Recommendation Report for Listed Building Consent for Alterations, Extension or Demolition**REF NO:** FP/175/17/L**LOCATION:** The Whyke House & Studio
47 Felpham Way
Felpham**PROPOSAL:** Application for Listed Building Consent to install secondary glazing to 10 No. existing windows.**SITE AND SURROUNDINGS**

10. STUDIO
MATERIAL - ALUMINIUM
INTERNAL & EXTERNAL COLOUR - WHITE
GLAZING - 4MM

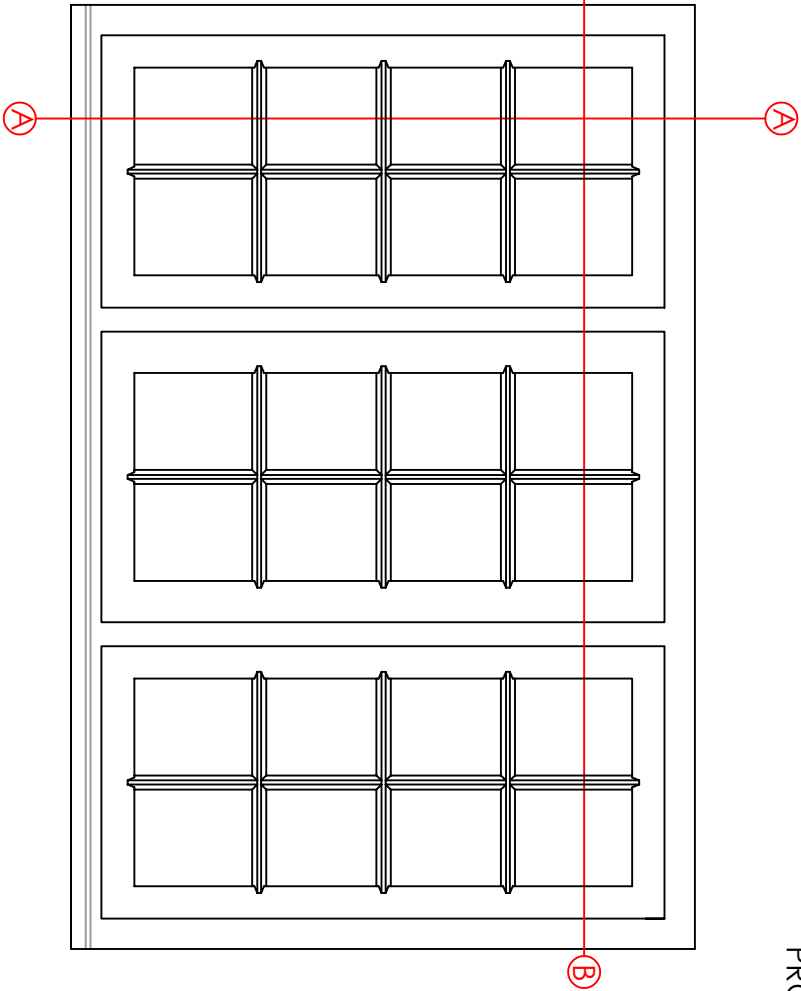
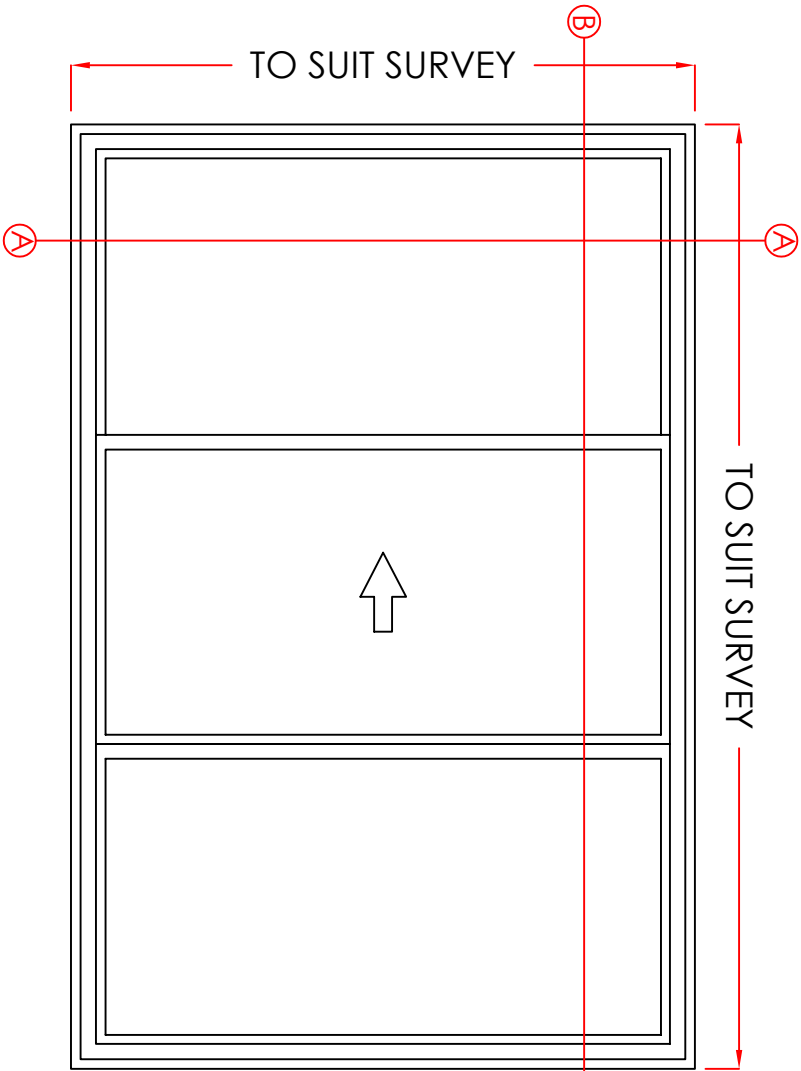
- 1 The proposed secondary glazing to the one window within the studio outbuilding and the nine windows within the house would be visually intrusive and would encroach on the

EXISTING & PROPOSED ELEVATIONS

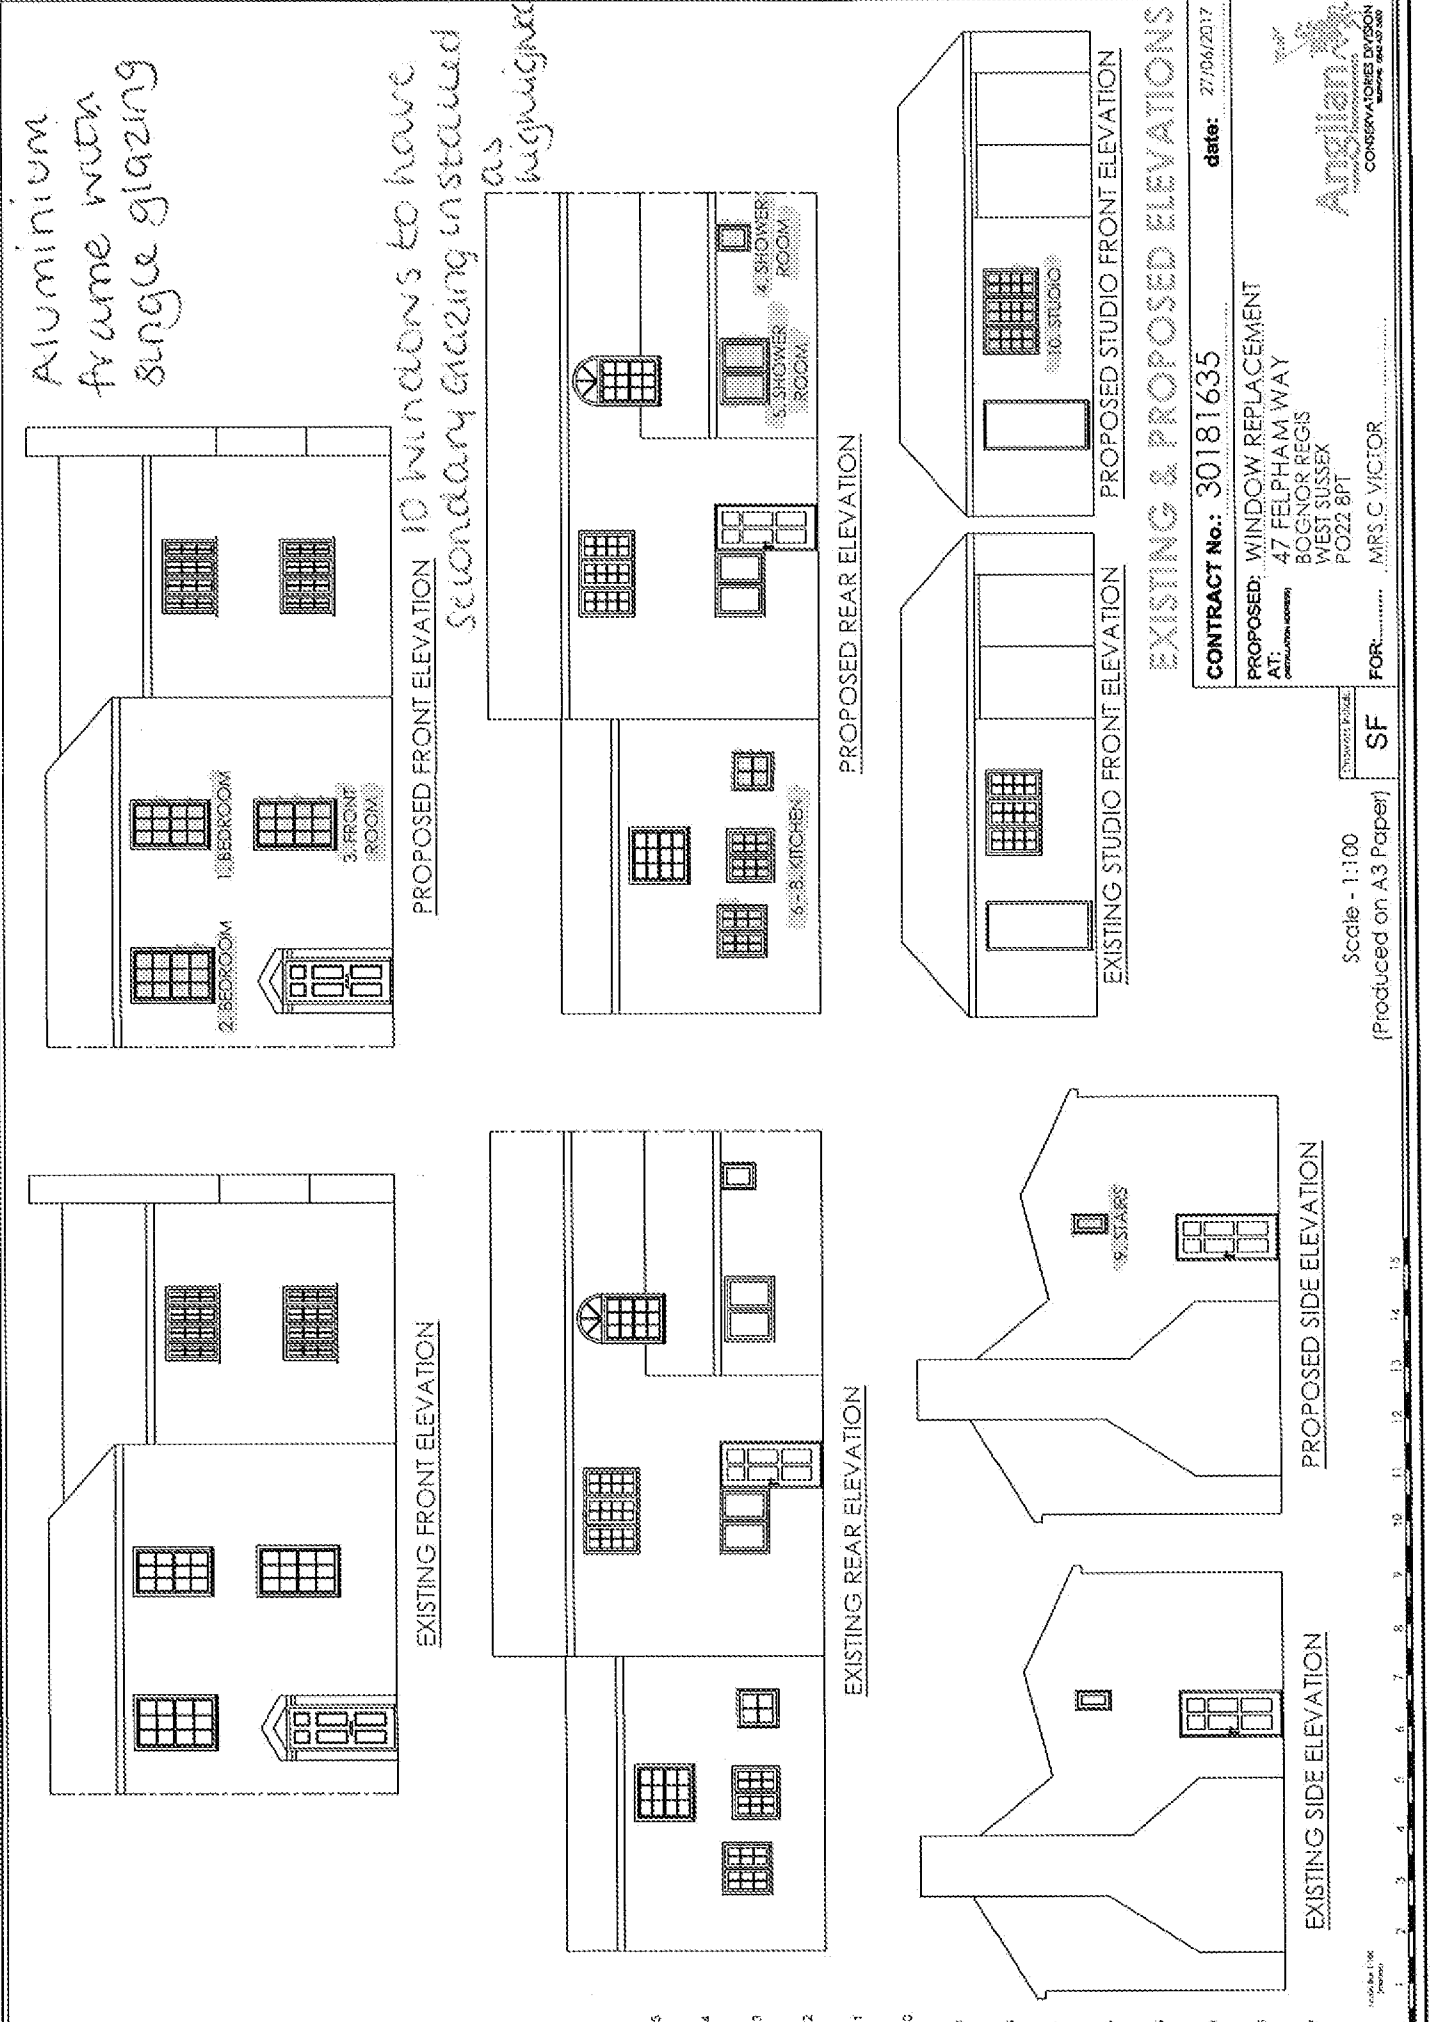
The Councils Conservation/Design Officer has appraised the application and considers that the proposed secondary glazing will be visually intrusive visually as there would be two layers of reflectivity which inevitably will have an adverse effect on the appearance of the property as a whole. Secondary glazing would also encroach on the historic timber window reveals (and possibly shutters).

historic timber window reveals & shutters to the detriment of the appearance of this Grade II Listed Building and would therefore harm the significance of the asset contrary to policy HER DM1 of the Arun Local Plan 2011-2031 Publication Version showing Modifications, paragraphs 132-134 of the National Planning Policy Framework and the supporting national Planning Practice Guidance.
